Oral submission to Open Floor Hearing 2nd July 2020, Simon Court on behalf of Cawston Parish Council

**Oral submission to Norfolk Boreas Planning Inquiry Open Floor Hearing 16th July 2020,
Simon Court on behalf of Cawston Parish Council.**

I would like to speak about the impact on pedestrian amenity in the village, aspects of the Cawston Highway Intervention Scheme and the Outline Traffic Management Plan

CAWSTON VILLAGE CENTRE - B1145
SCALE - 1:500

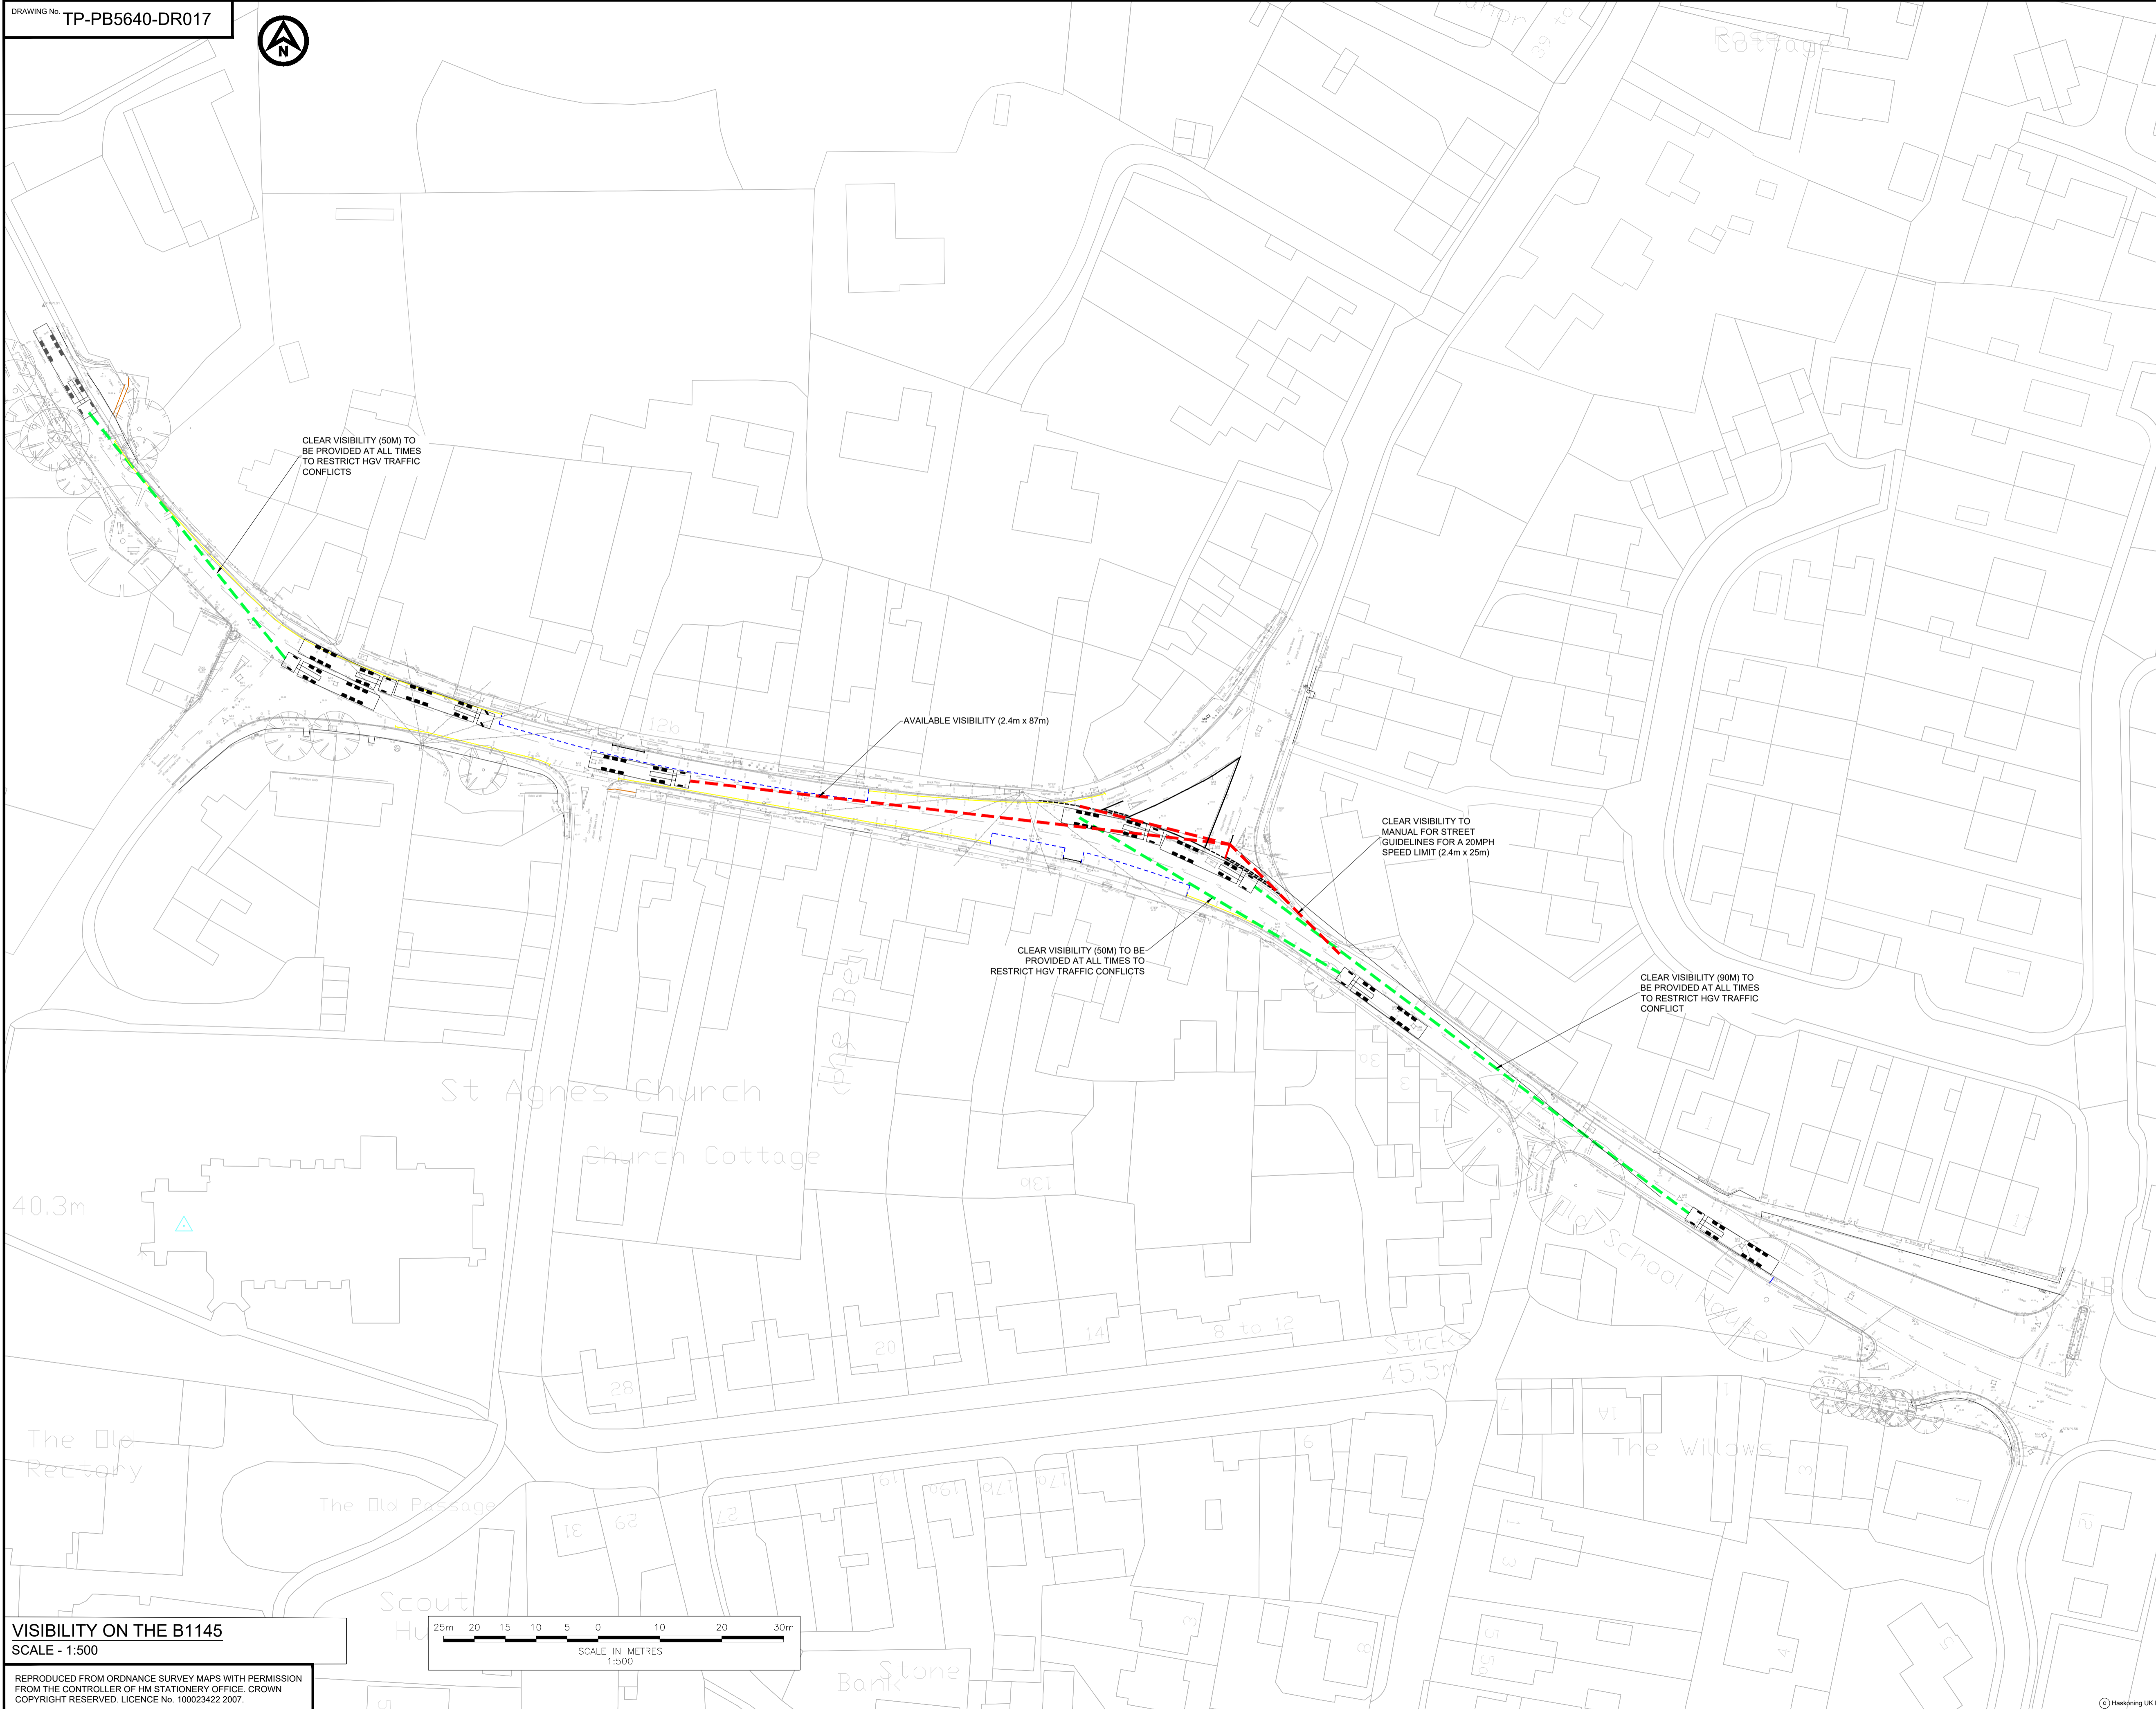
The applicant's forward visibility plan has green lines marked from the junction with Booton Lane which show a line of 50 metres which is to be kept clear at all times to restrict HGV conflicts. These lines can only provide visibility when there is no traffic ahead of the HGV obscuring the view. 50 metres is not a great distance for an HGV to stop from 20mph. The stopping distance for a car at 20mph is 12 metres and even longer for an HGV, by which time the vehicle will come to rest in the HGV conflict zone, making it difficult or impossible for oncoming traffic, including the applicant's HGVs or even the service bus to pass.

CAWSTON VILLAGE CENTRE - B1145
SCALE - 1:500

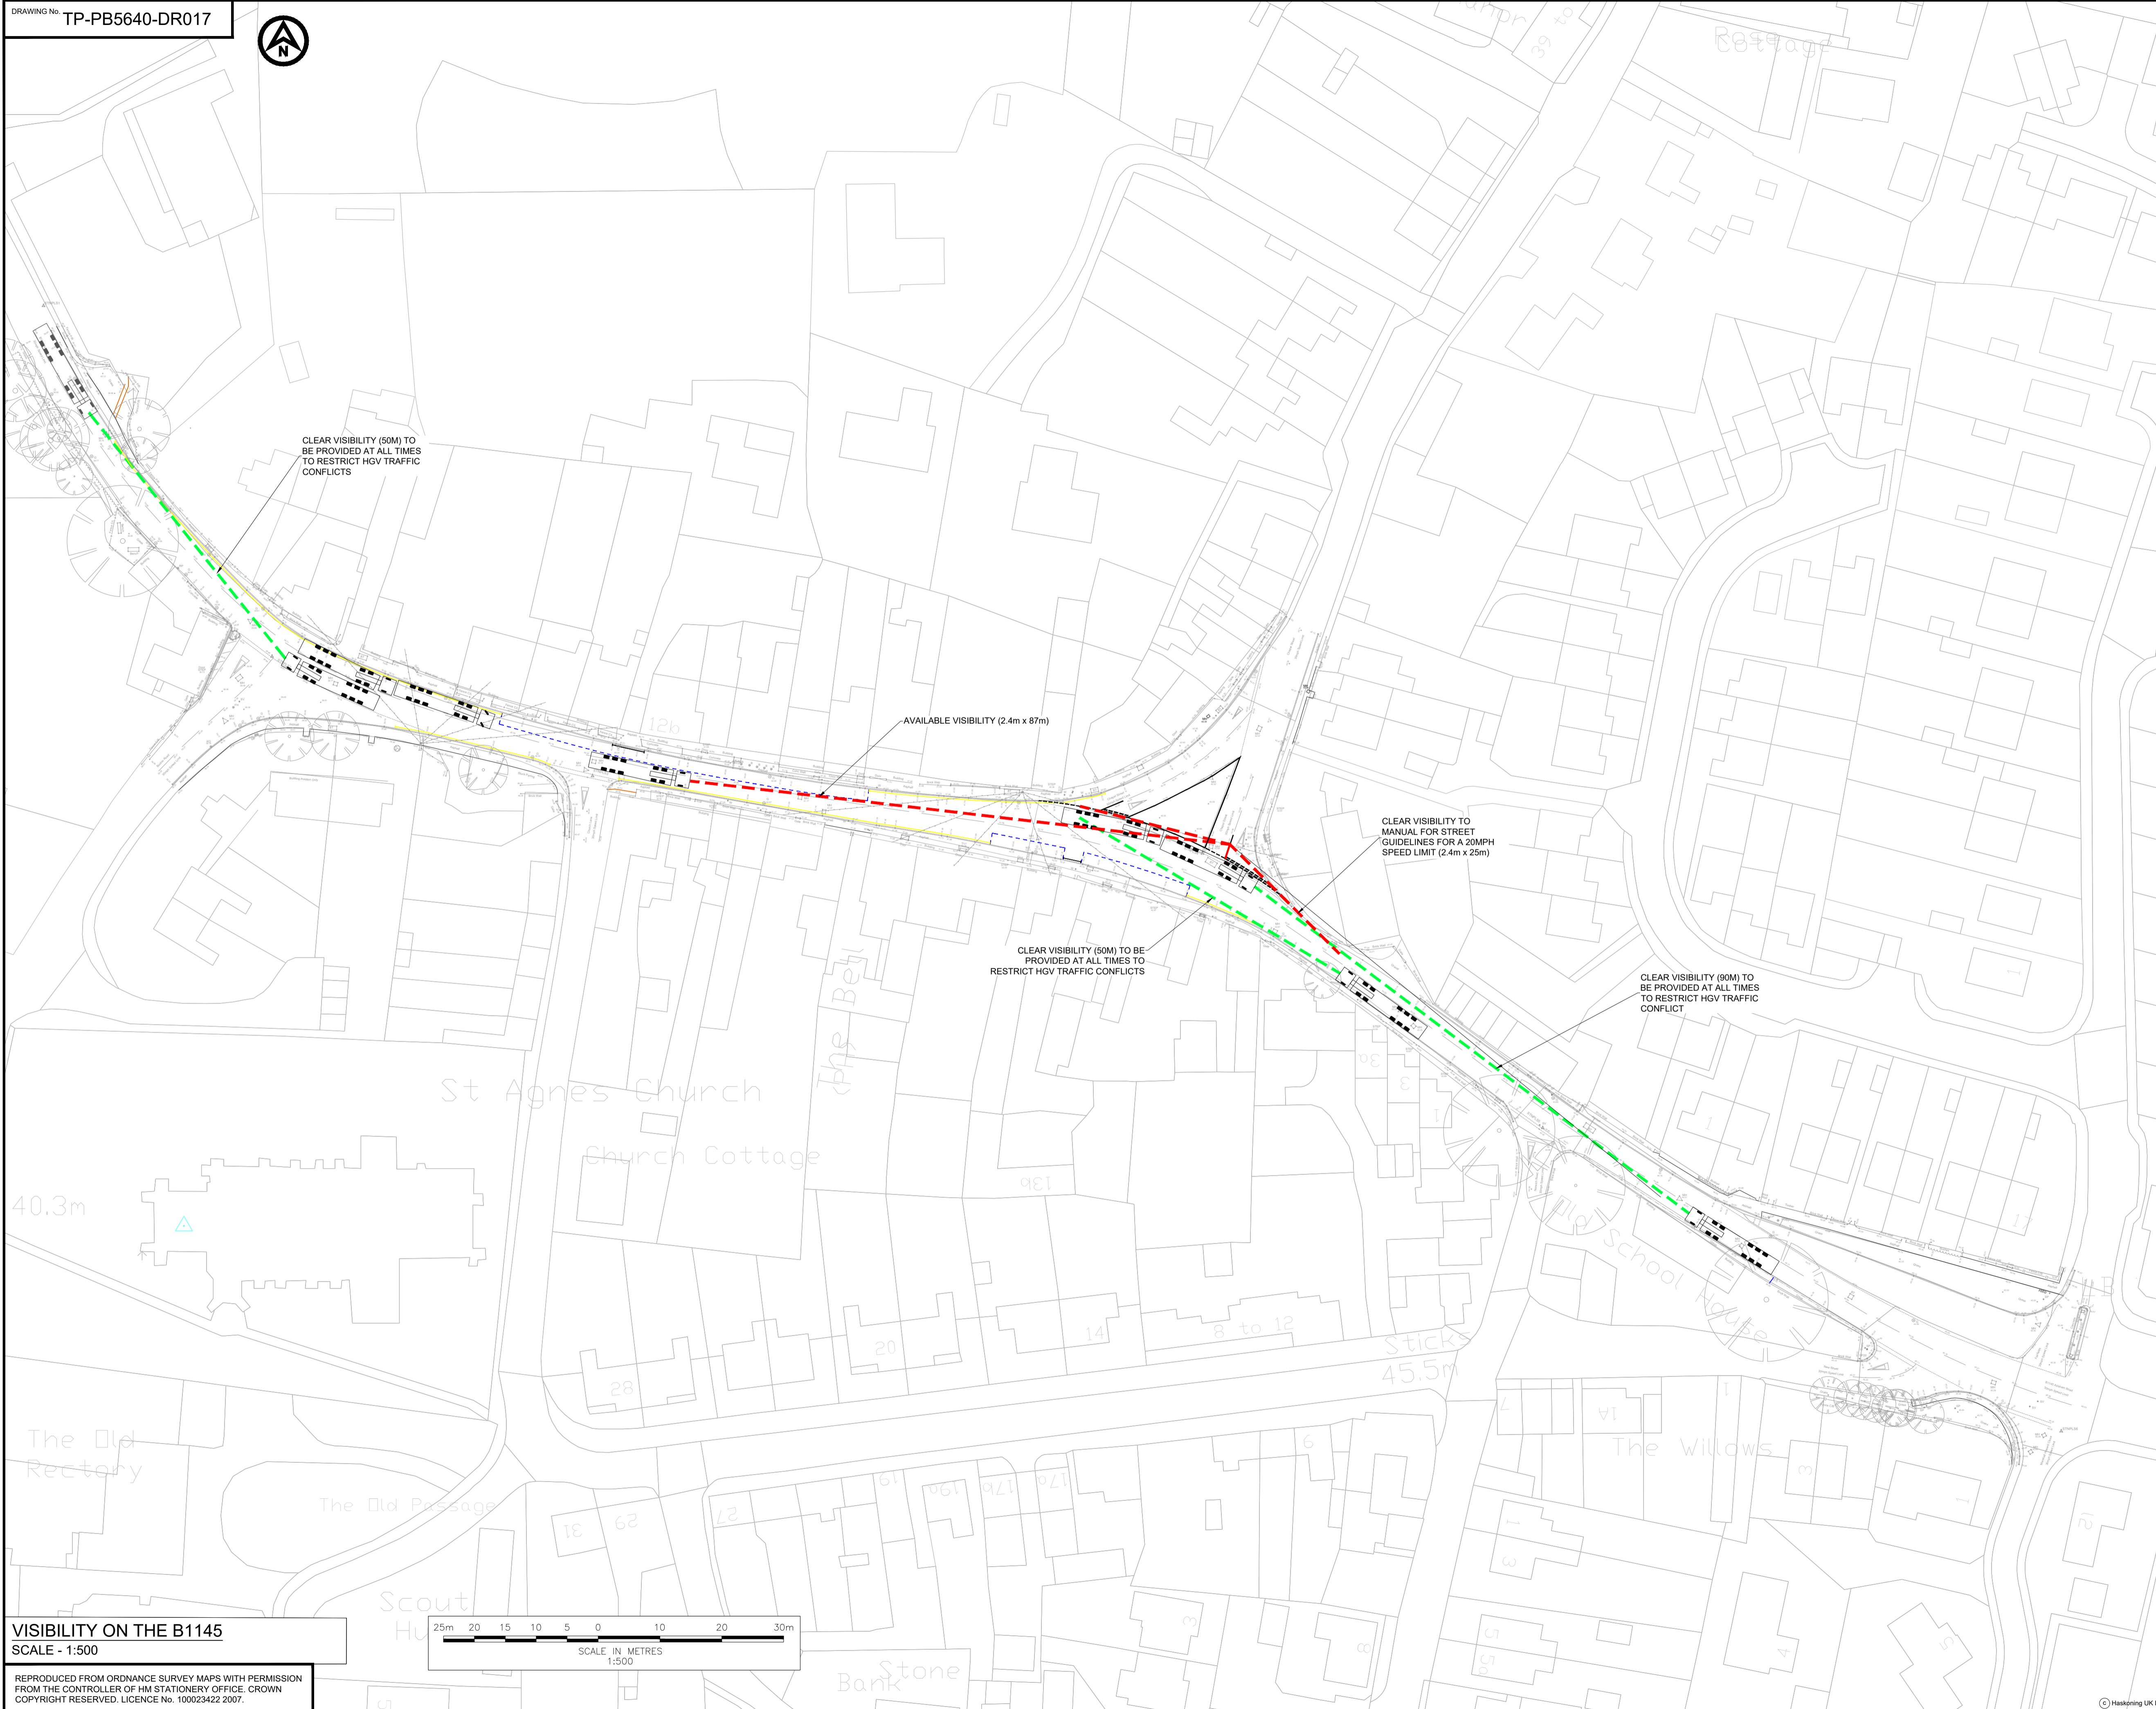
The HIS designates a passing space at the junction of Booton Lane, labelled on the swept path plan as *No conflict when third large tipper in queue is stationary*. This boast relies on no other vehicle finding its way between the three tippers, an unlikely scenario since other vehicles do use the B1145 and the Traffic Management Plan suggests that HGVs will be released at spacing to avoid platooning.

In the event that one tipper travelling from the west is followed by say a couple of cars and a van and they can find their way across Salle Beck Bridge, over the old railway bridge avoiding pedestrians in the road and eventually arrive at the HGV passing space at the junction with Booton Lane then a second tipper, and any other following traffic, would find itself waiting, not in the designated passing place, but in what is marked on the swept path analysis plan as a potential *two way Large Tipper HGV Conflict Zone*, effectively barring progress of all but the narrowest oncoming vehicles travelling from the east. If the second tipper has collected traffic behind, likely in a 20mph zone, there would be no opportunity to enable approaching traffic to pass. A third tipper following may well be stuck in a stream of traffic on the old railway bridge, also obstructing oncoming traffic.
